Application No: M/2/21/HH
Site Address: 45 Southdean Close Middleton-On-Sea PO22 7TH
Description of works: Two storey front extension, first floor side extension, single storey side extension, two storey side extension, conversion of roofspace to habitable use with rear dormer and installation of 4 x balconies.

Thank you for your internet representation made on 15th February 2021 which has been recorded as an objection with the comments as follows:

Drawing Title:
PROPOSED FLOOR PLANS & ELEVATIONS

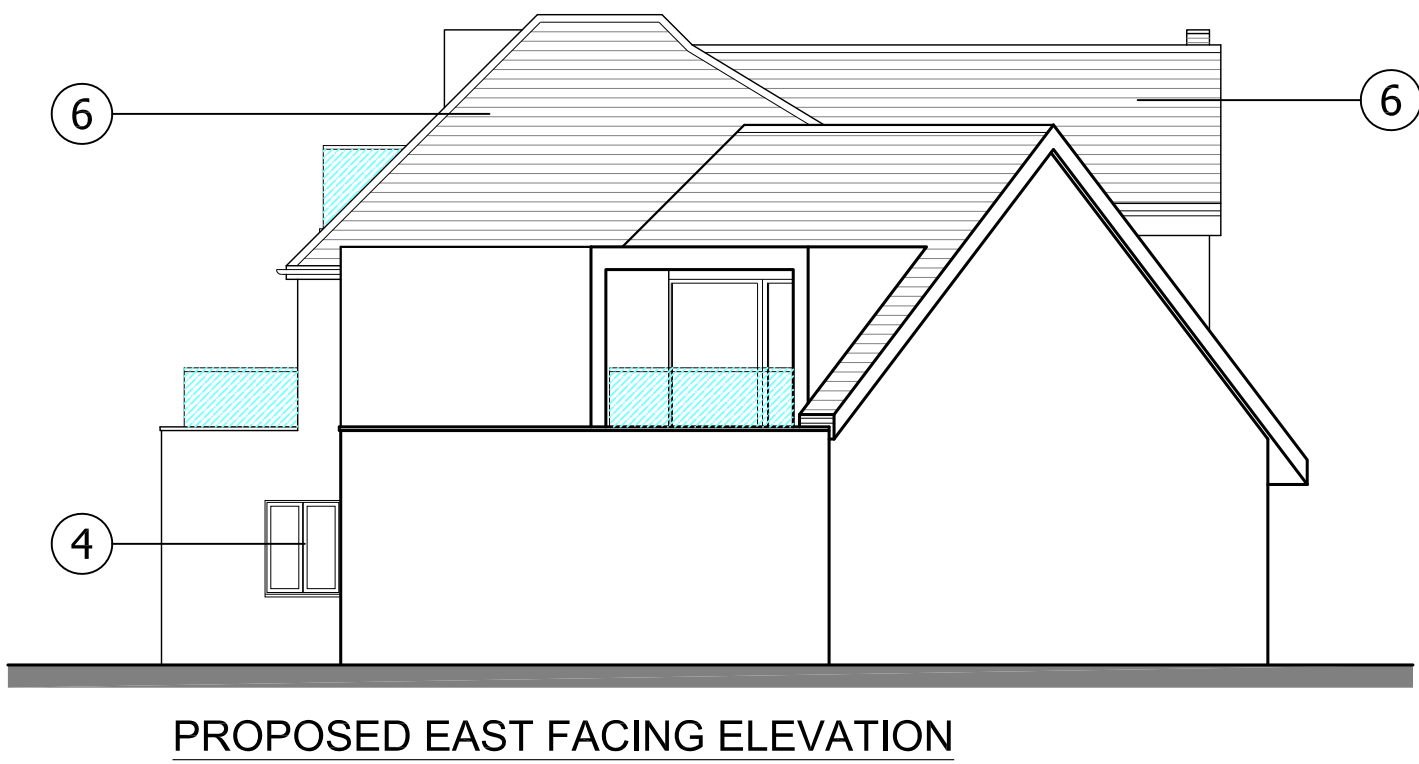
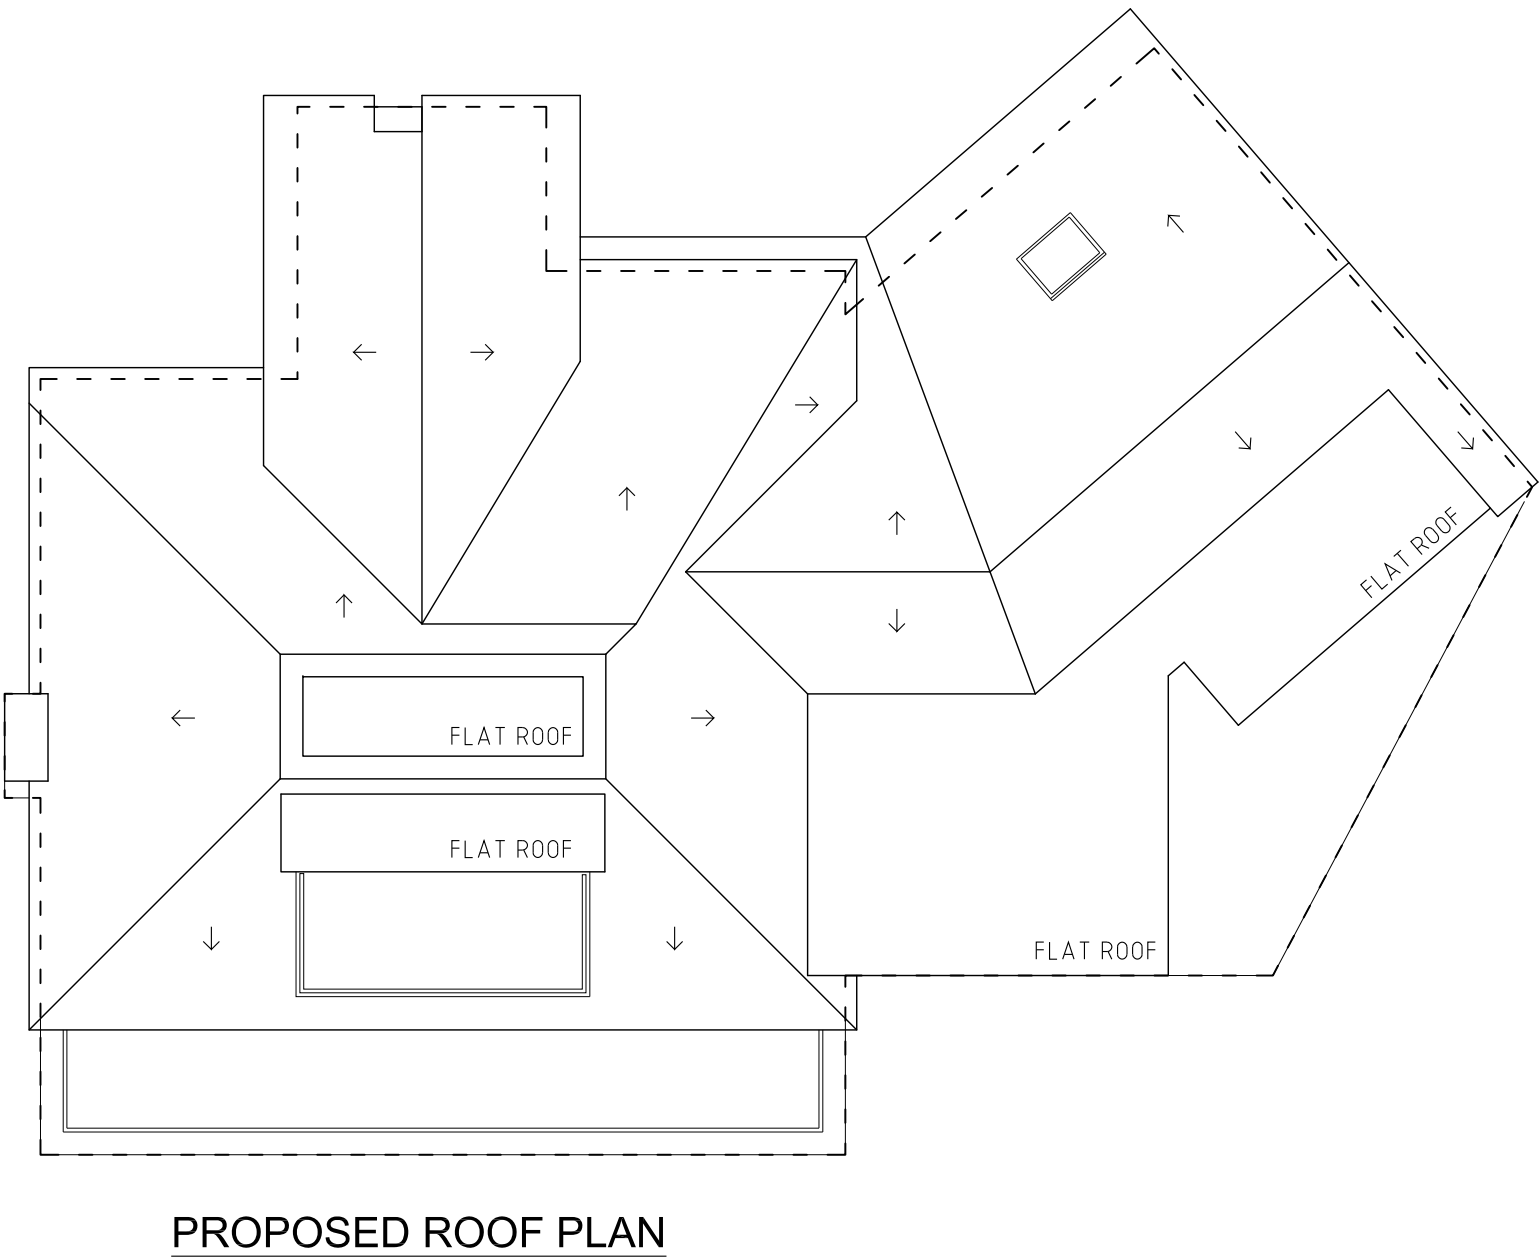
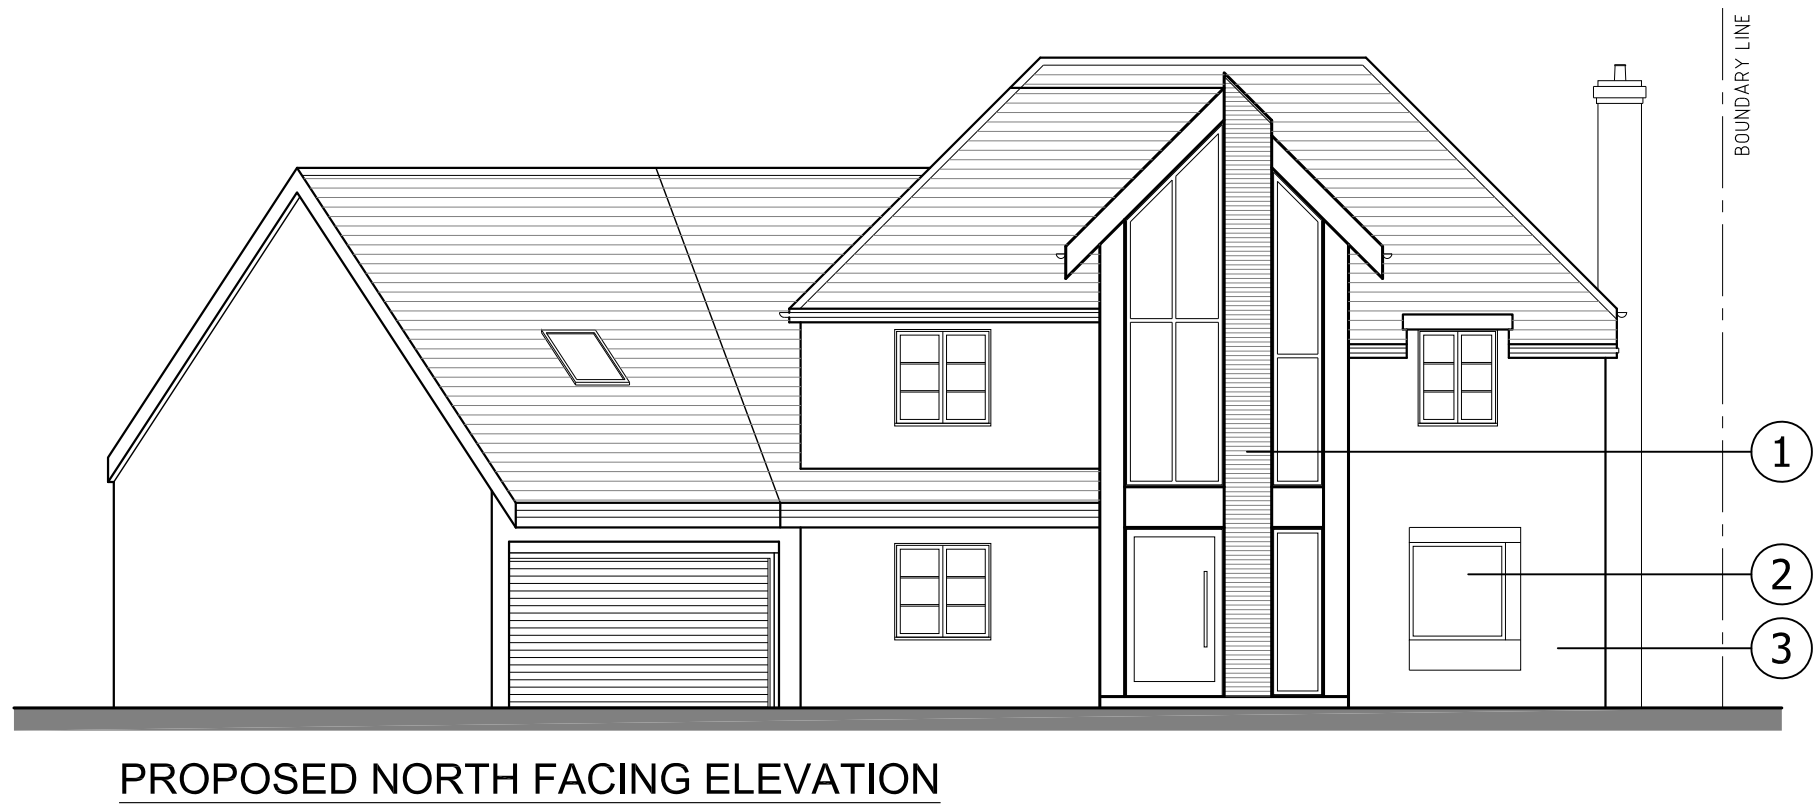
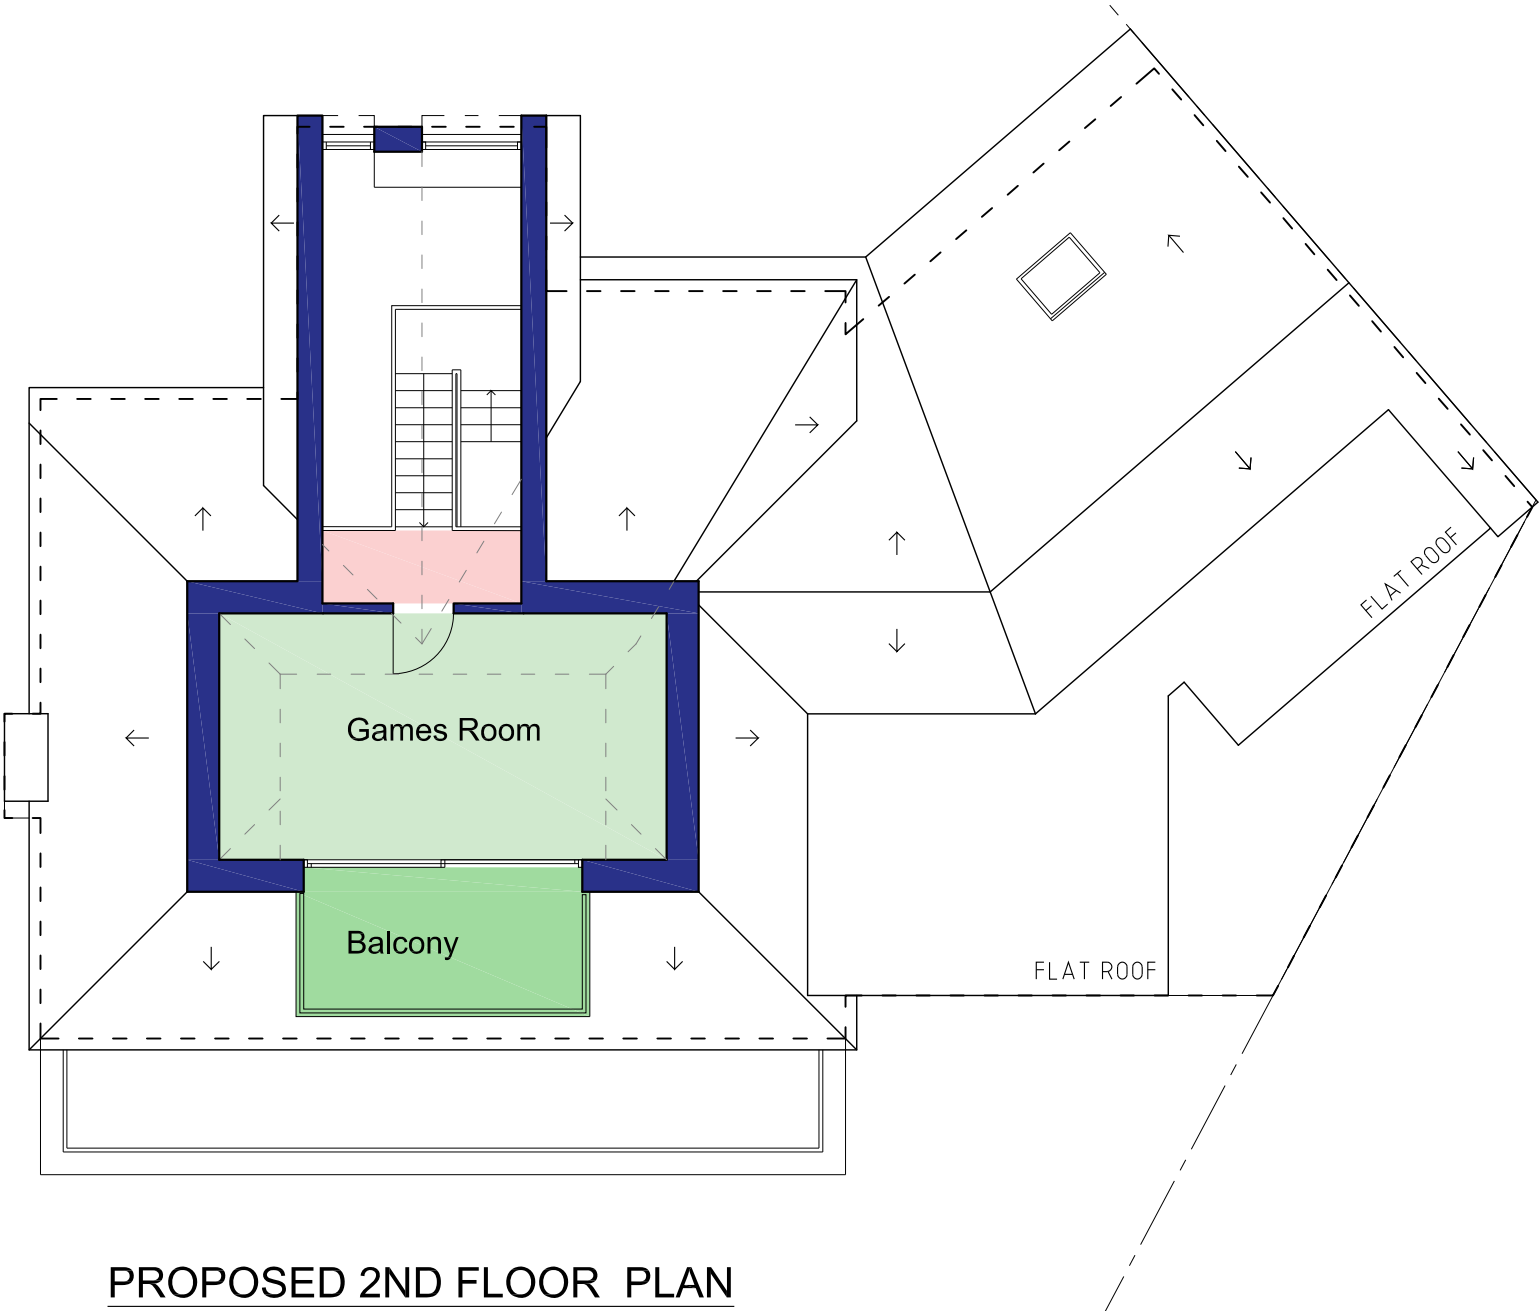
The proposed front extension is higher than the existing roof and is not in keeping with this small close. The proposed side extensions will be too close to houses on both sides of the property plus one house on the Elmer Beach estate. The conversion of the roof to include bedrooms and balconies effectively will make this 3 floors, again too large for the plot.
